13 July 2017

Re Planning Application A/87/17/HH The Old cottage, Station Road, Angmering

PROPOSED FLOOR PLANS 1:50

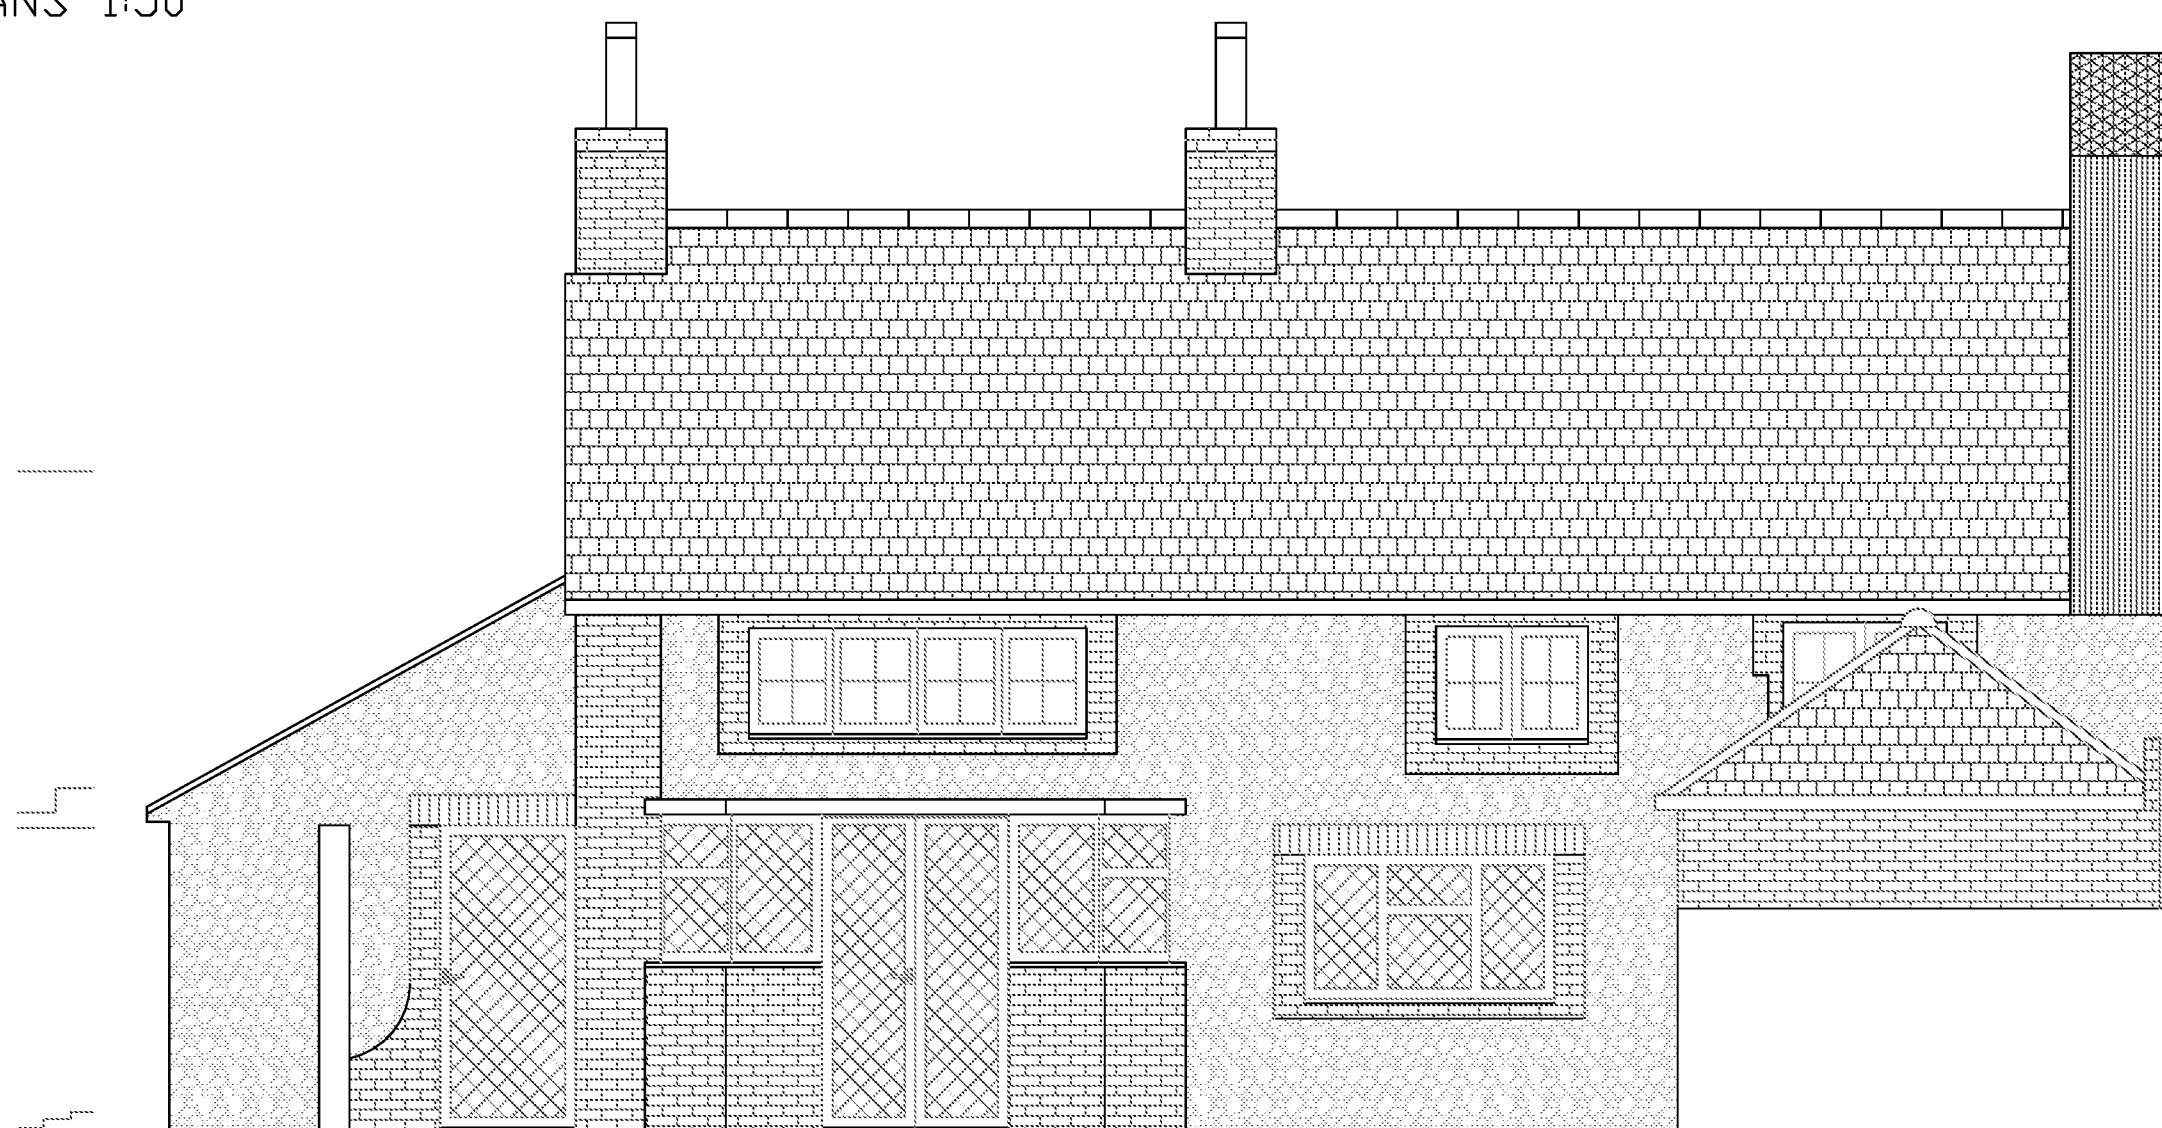
Furthermore, should the Hinds get permission to build this extension it deeply affects my mothers house next door – the current outside wall of his extension kitchen is right outside my mothers kitchen window and conservatory and is a party wall. The flat roof of the existing extension is directly under my mothers bedroom window and to put a pitched roof on this extension (and the extension to the extension which he is

planning) would gravely alter the look of the back of these properties and is out of keeping with line of the building, and the appearance and character of a beautiful thatched seventeenth century grade 2 listed building.
